# DEVELOPMENT FACILITATIVE TEAM (DFT)

**PR-2022-007999**

SI-2024-00582– EPC SITE PLAN SIGN-OFF  
SKETCH PLAT 12-2-22 (DRB)

**REQUEST:** EPC SITE PLAN SIGN-OFF

- KEYED NOTES**
- PROPERTY ENTRY
 - MAIL BOX
 - RECYCLE CENTER
 - BATHROOM MODULE
 - SITE DUMPSTER
 - OFF-GRID LANDSCAPE MAINTENANCE STATION (rain water capture from storm system and solar powered with battery backup timer/drip system)
 - OUTDOOR SEATING AREAS
 - BIKE RACKS (5 BIKES EACH RACK)

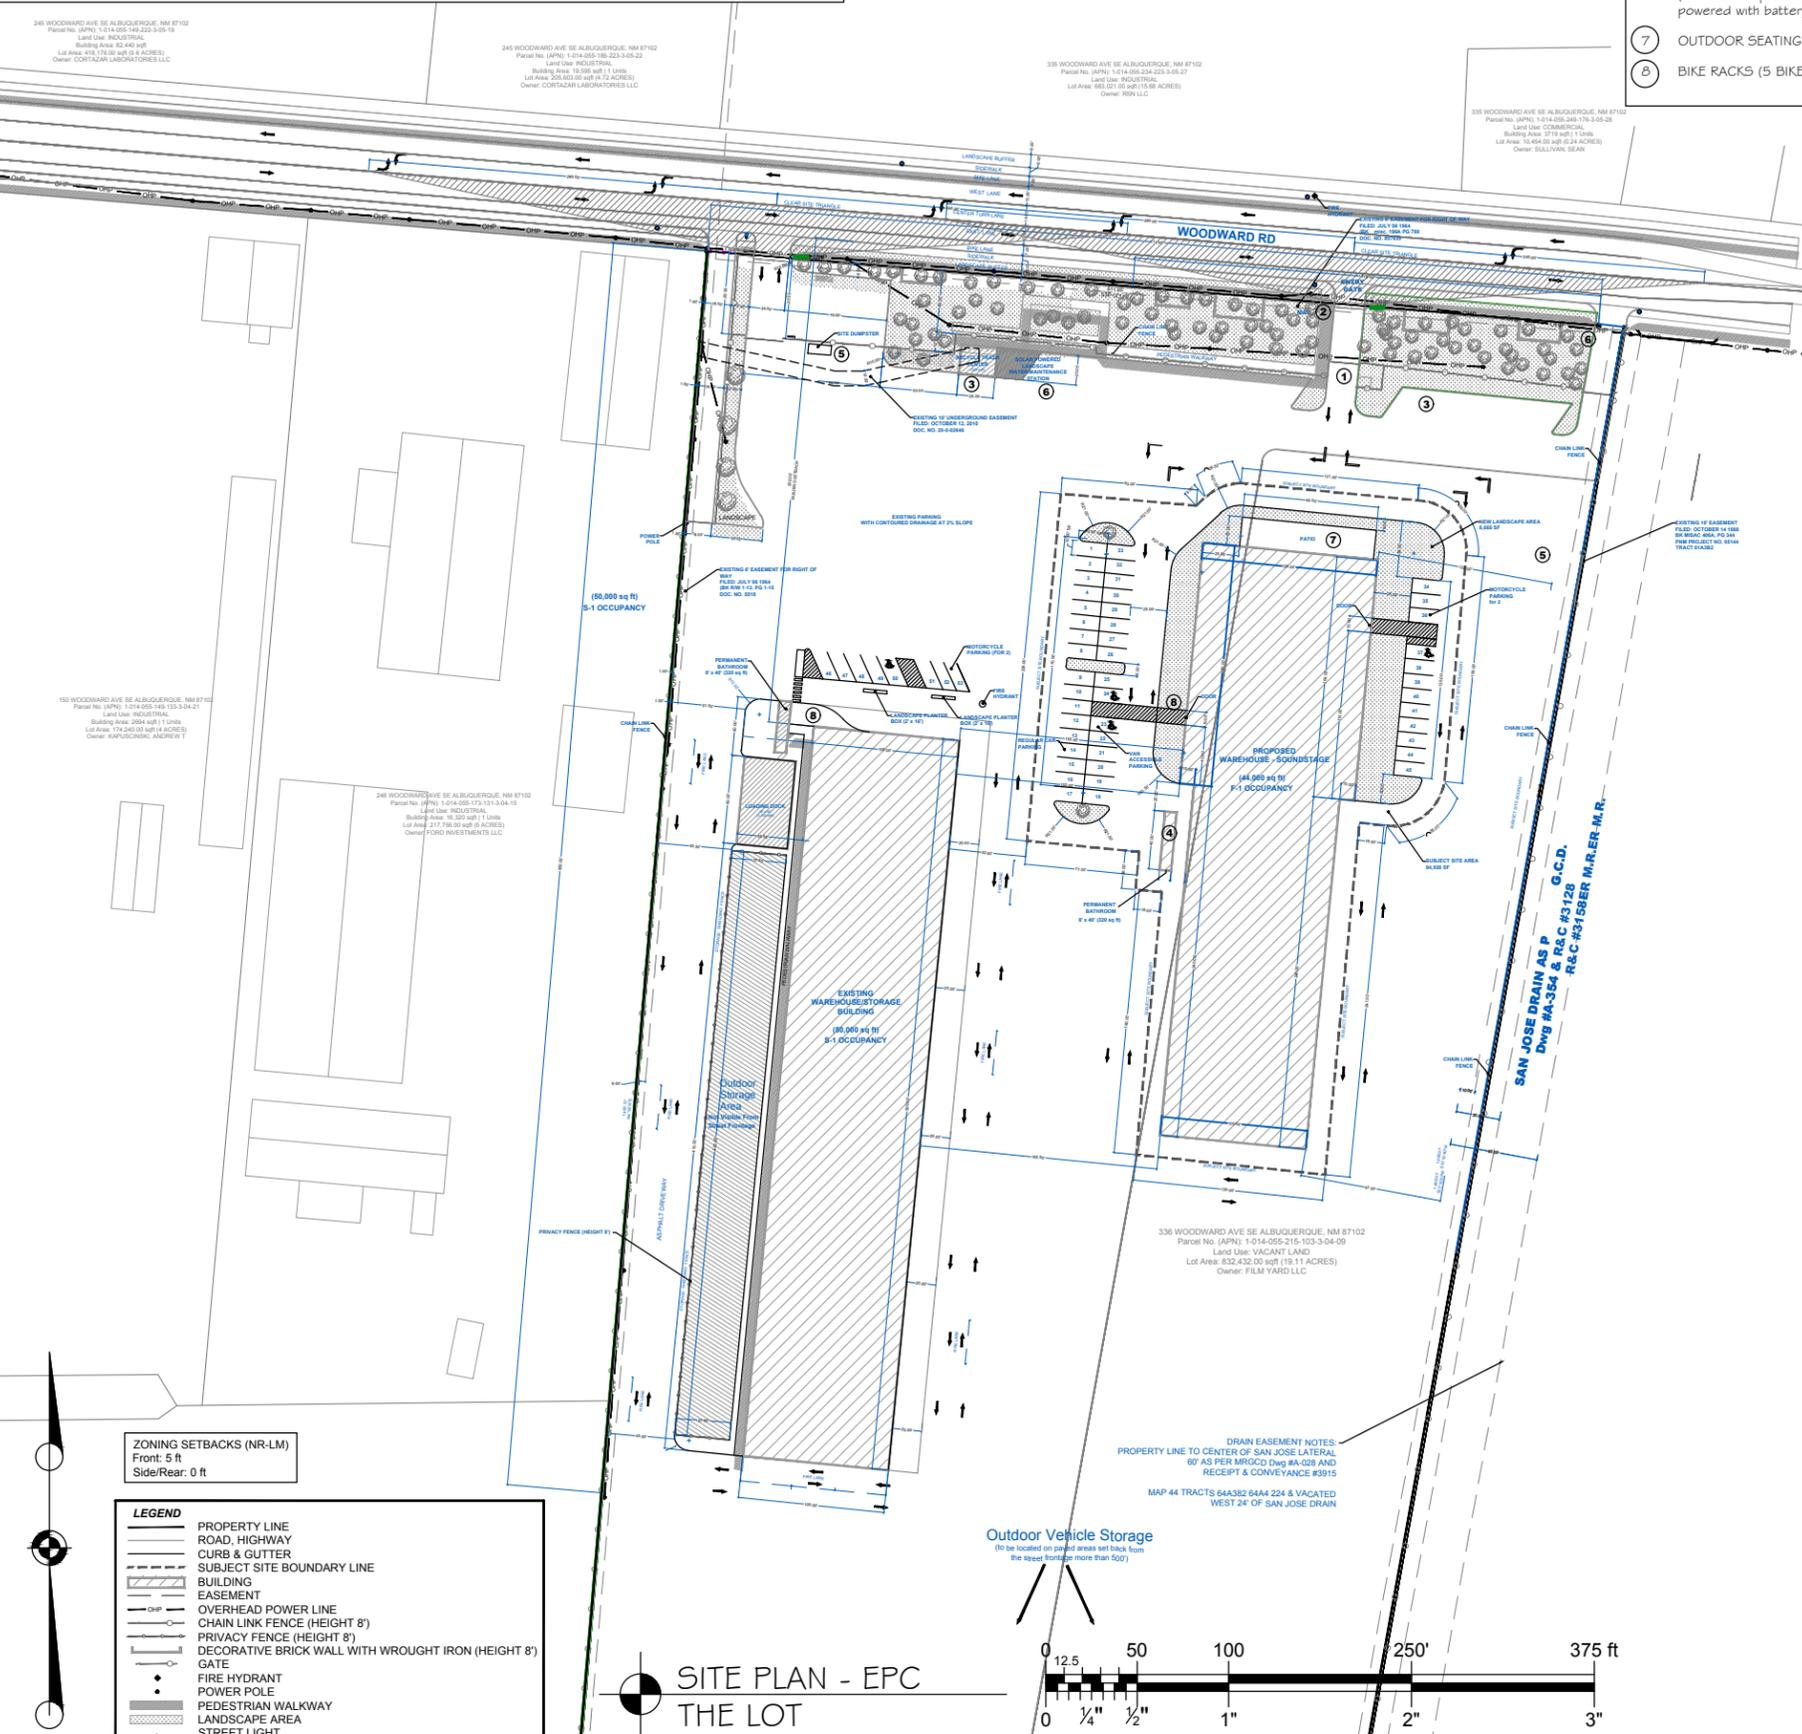
4. Please identify where site dumpsters are located (indicated as Note #5, but could not find that on map).
5. Please note that this plan was approved by the EPC strictly for the use as a dry storage warehouse, with no utilities, as noted on the EPC approved site plan (General Notes #4 & #5).

Seal: Landscape Architect
STATE OF NEW MEXICO
DANNY D. MITCHELL
239
REGISTERED LANDSCAPE ARCHITECT
Nov. 21, 2024
Copyright 2024, Mitchell Associates Inc.
PROJECT NO. 2024-055
DRAWING NO. LS-101

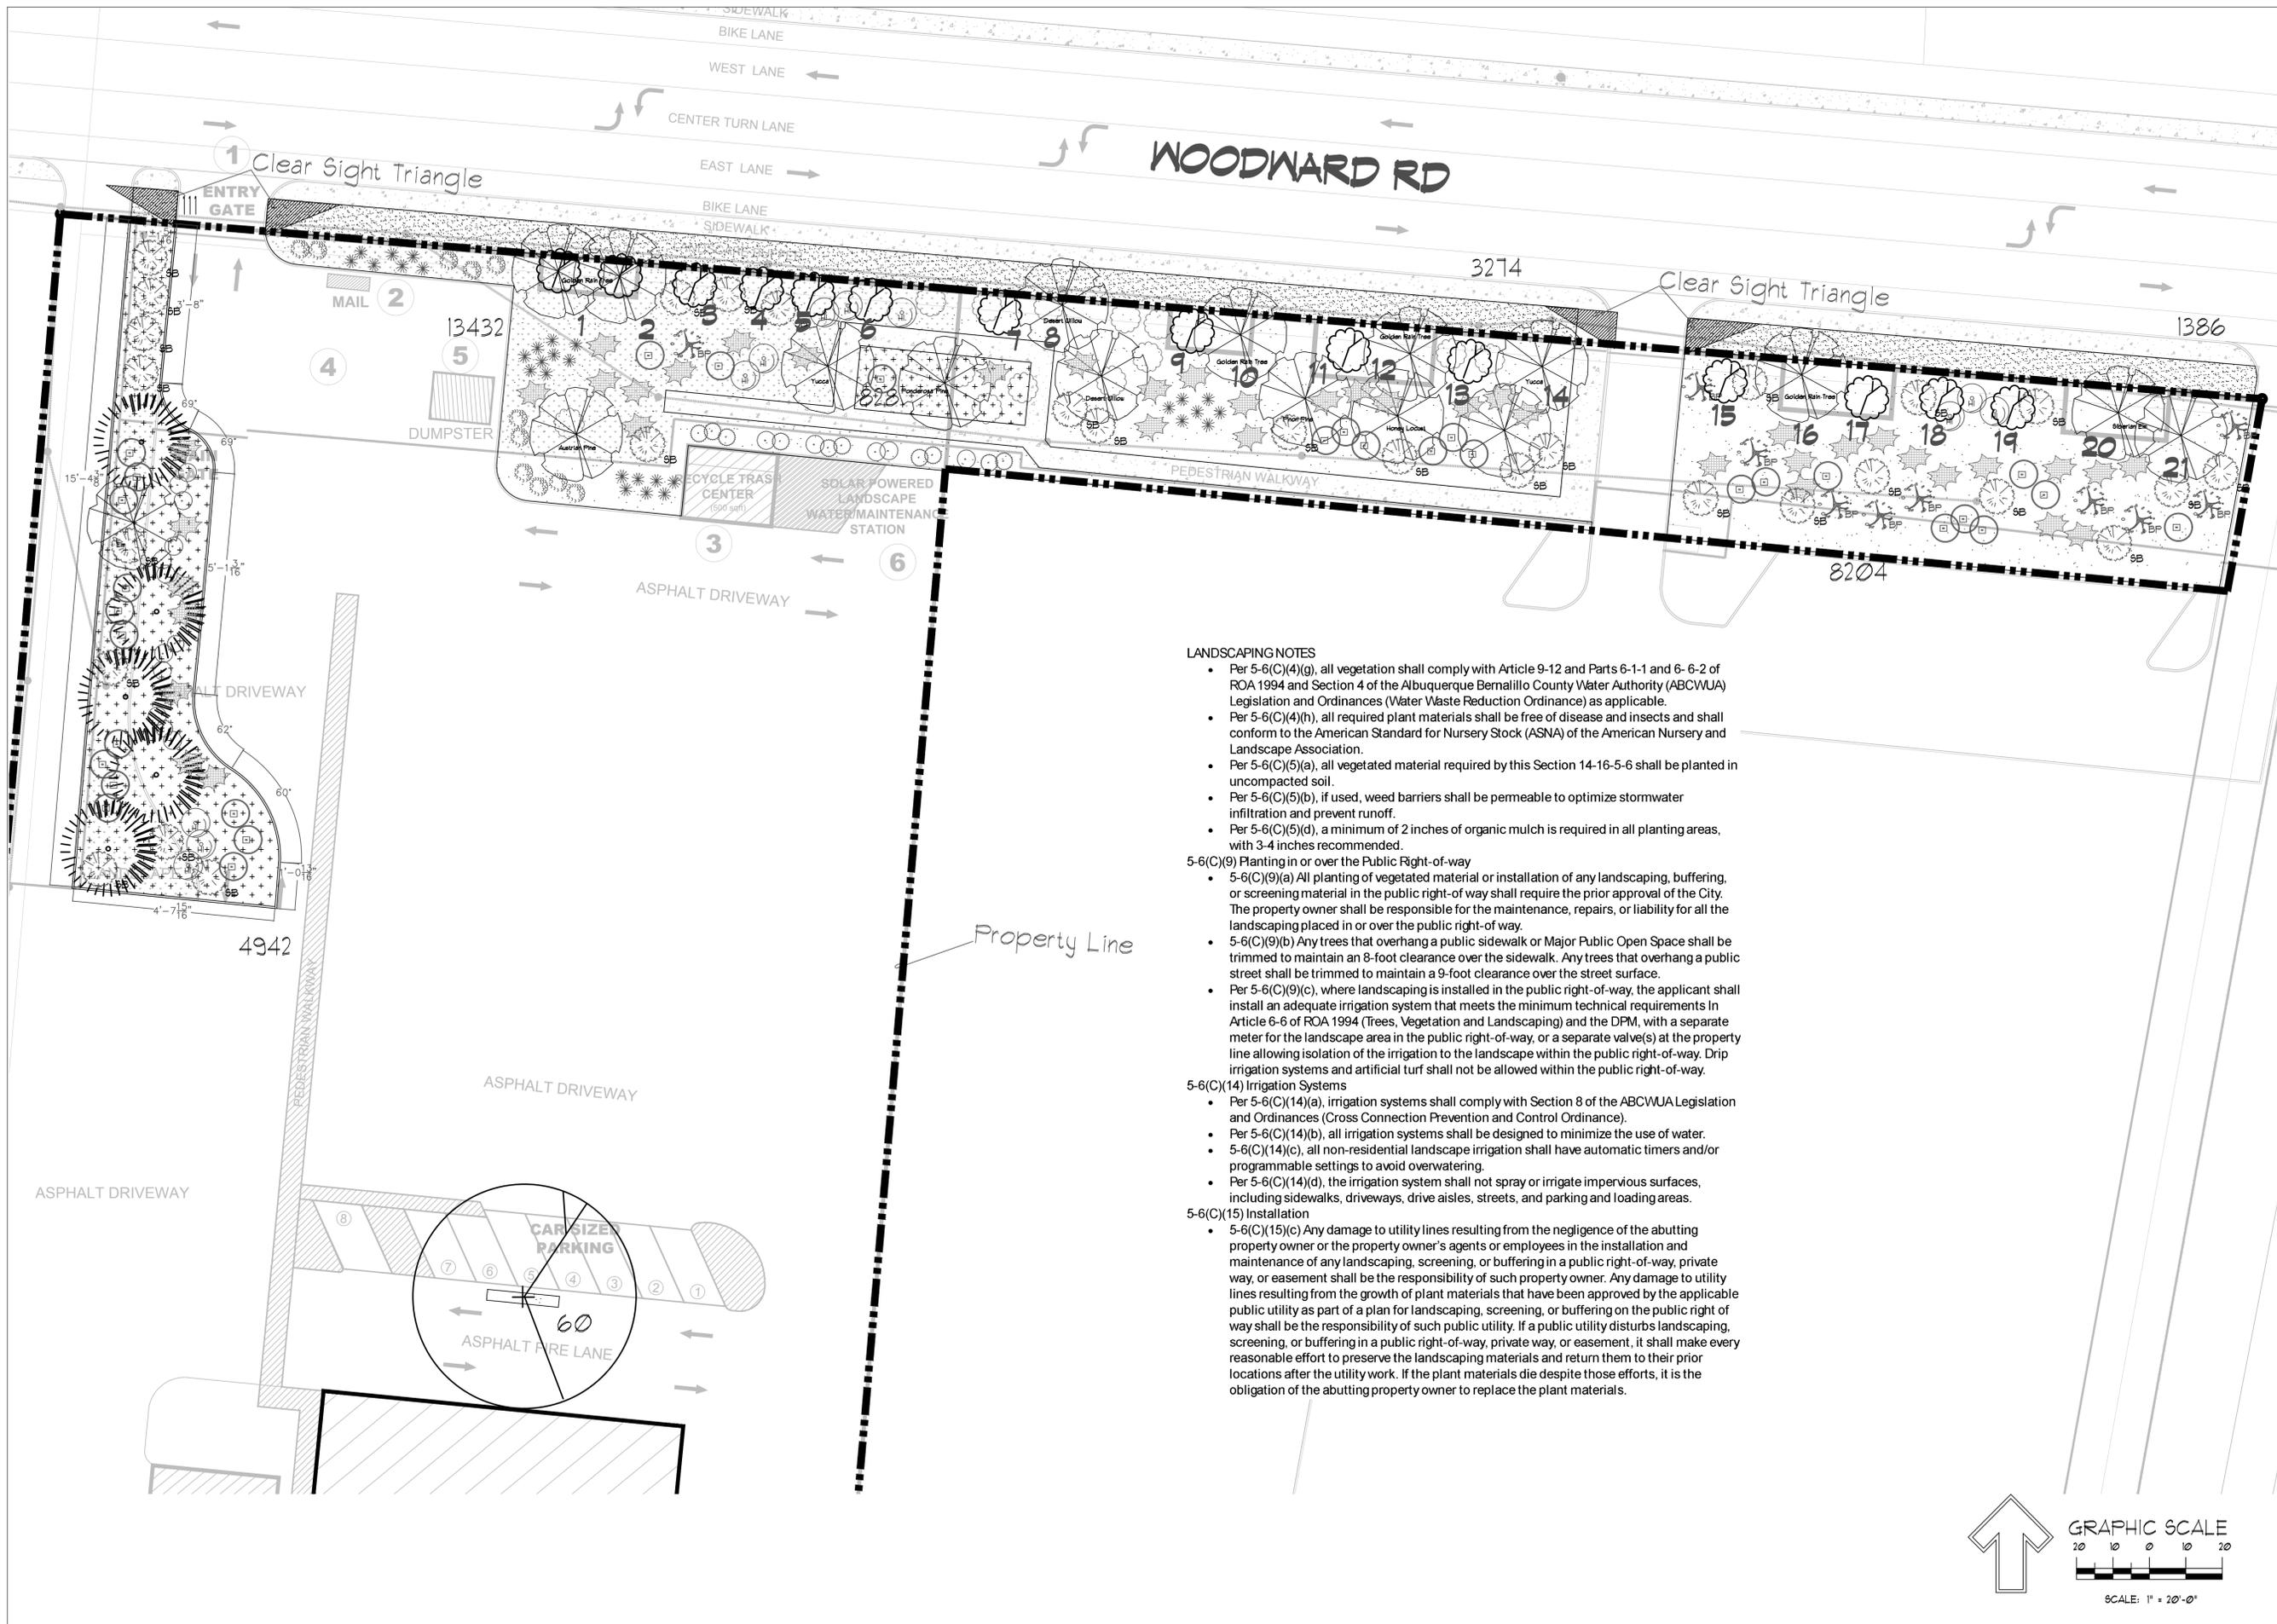
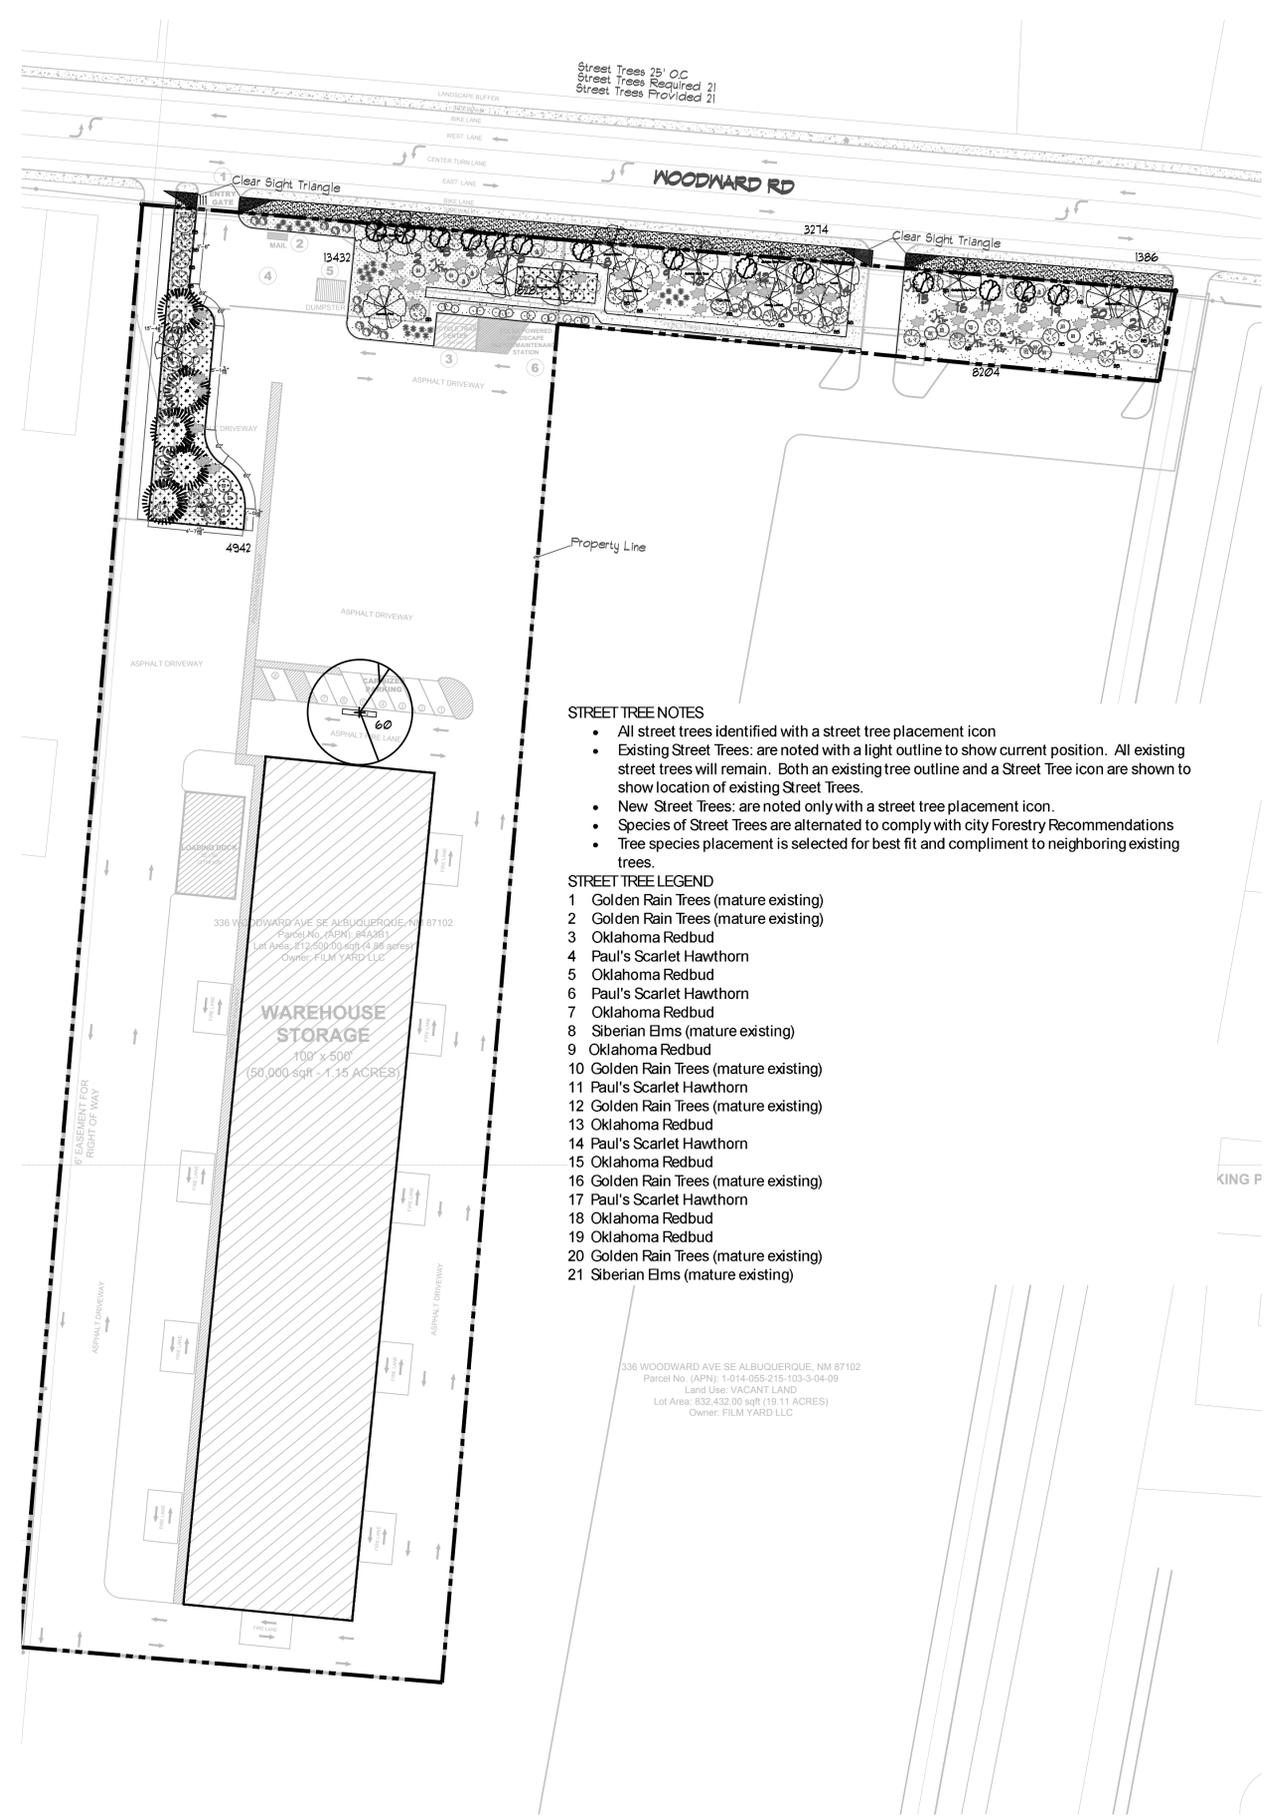
- Per 5-6(C)(5)(e), organic mulch is required as ground cover under trees within a 5- foot radius around the tree trunk, but not directly against the trunk. In these areas, weed barrier fabric is prohibited. (See figure below.) **Add a tree planting detail addressing this code.** The organic mulch used under the trees can be counted towards non gravel mulch used on the site as discussed under 5-6(C)(5)(c). Please make sure you are mention **'Organic Mulch'** on your planting details.

- Are there plans to remove the existing wall and trees along Woodward or is it planned to keep what is currently in place? The landscaping plan submitted to EPC does not reflect the existing wall correctly nor does it show the existing trees in the plan. Adjust the plan to show the existing wall and trees correctly. Most Existing trees seem to be viable and per City Forester comment must be maintained. More comment from City Forester will be provided to the applicant.
- The landscaping plan submitted to the EPC shows a row of Pinon Pine trees along the existing wall. It is recommended by the city forestry team to alternate species of trees to reduce the impact of any potential disease. Adjust the landscape plan to reflect alternating species. Austrian pines, and Afghan pines are both recommended evergreen trees for Albuquerque per City Forester.

- Per 5-6(D)(1)(a), all development shall comply with Part 6-6-2 of ROA 1994 (Street Trees) and any standards developed by the Parks and Recreation Department or other City department to implement that Ordinance. Trees are generally required along street frontages every 25 feet on center unless specified otherwise in Part 6-6-2 of ROA 1994 (Street Trees). Along street frontages where street trees are required, trees that are planted within 20 feet of the back of curb of the abutting street may fulfill this requirement. (See figure below.)
